PINs Registration and Relevant Representation Form on behalf of Historic England

Project : Stonestreet Green Solar Farm

TR010032

A solar farm of 192 hectares is proposed on agricultural land within the Upper Stour valley near Ashford (south of M20) in Kent. The proposal includes on-site energy storage, associated infrastructure, an underground cable connection to a nearby substation, screening through planting and a series of off-site landscape improvements.

Drawing Title: **Illustrative Landscape Strategy Plan Sheet 2 of 5 Not for Approval**

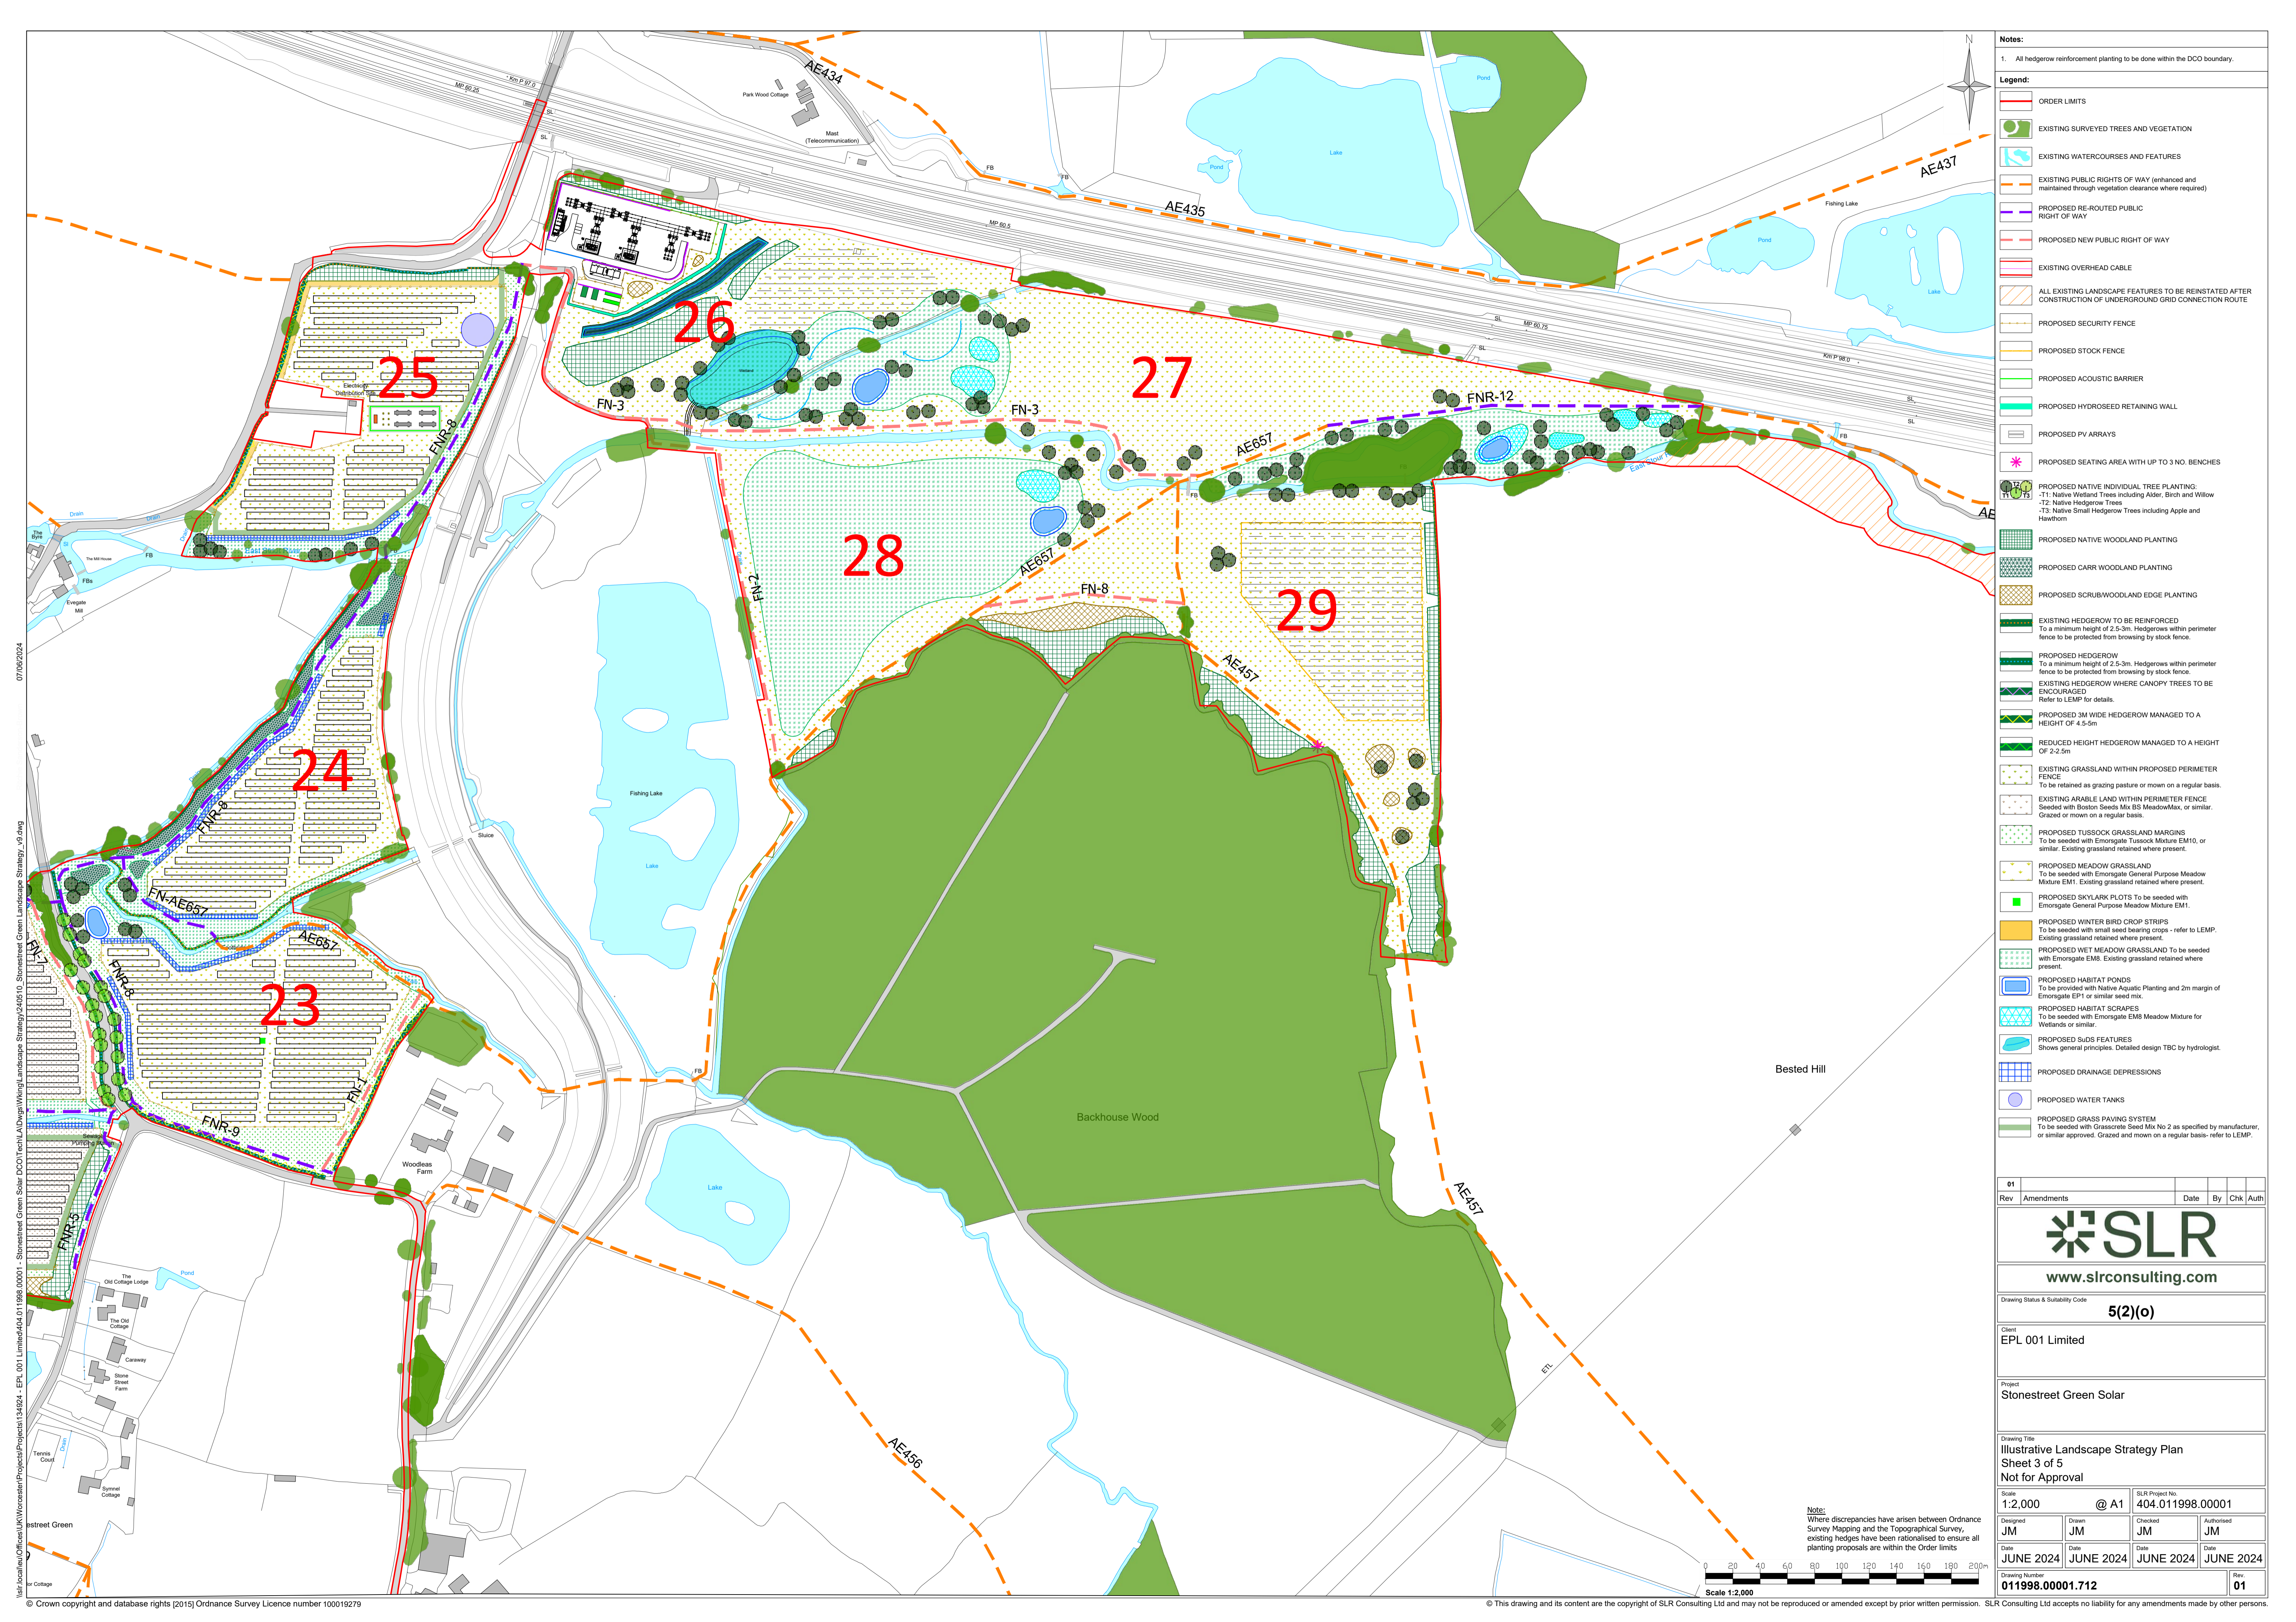
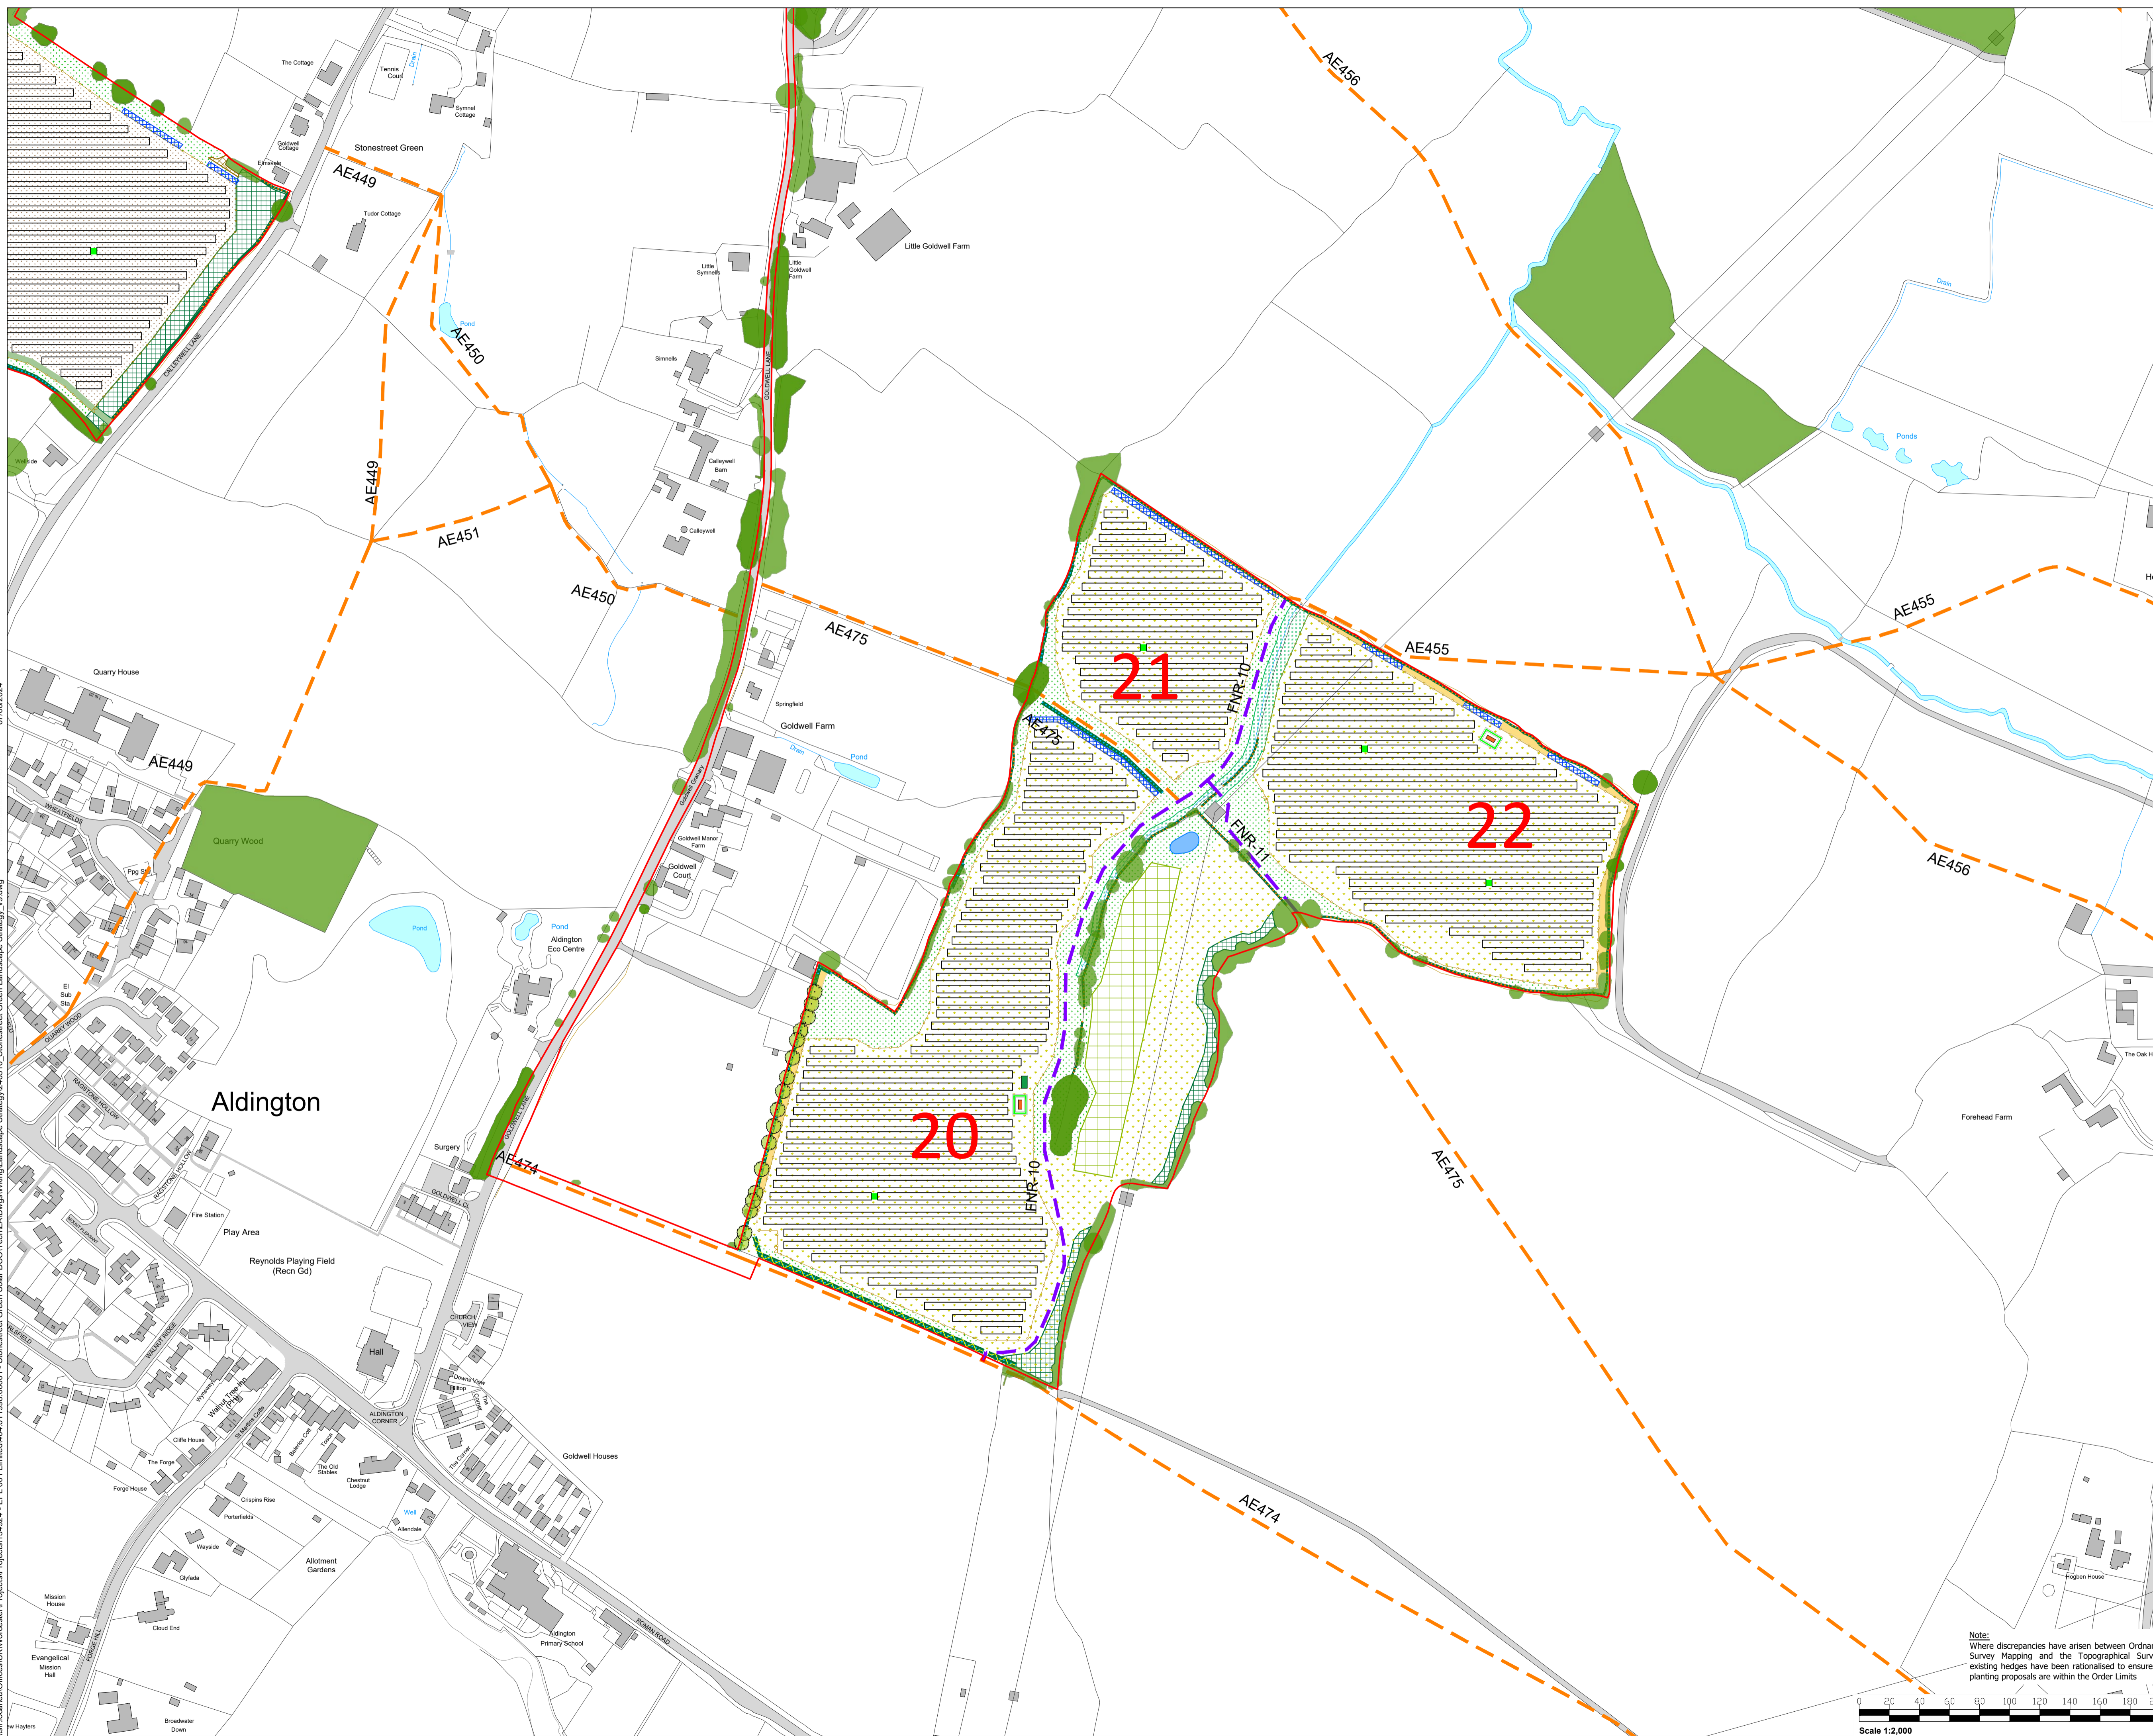
At the south-west corner of the site, the panels would cover fields which historically formed the estate of the Stonelees House, a medieval hall (Grade II*: NHLE 1233761). We have identified harm to the building's significance (because of a historic association). We would also encourage the applicant to explore opportunities to reduce harm to Stonelees, for example, by reducing the number of solar panels at the south ends of fields 3 and 7.
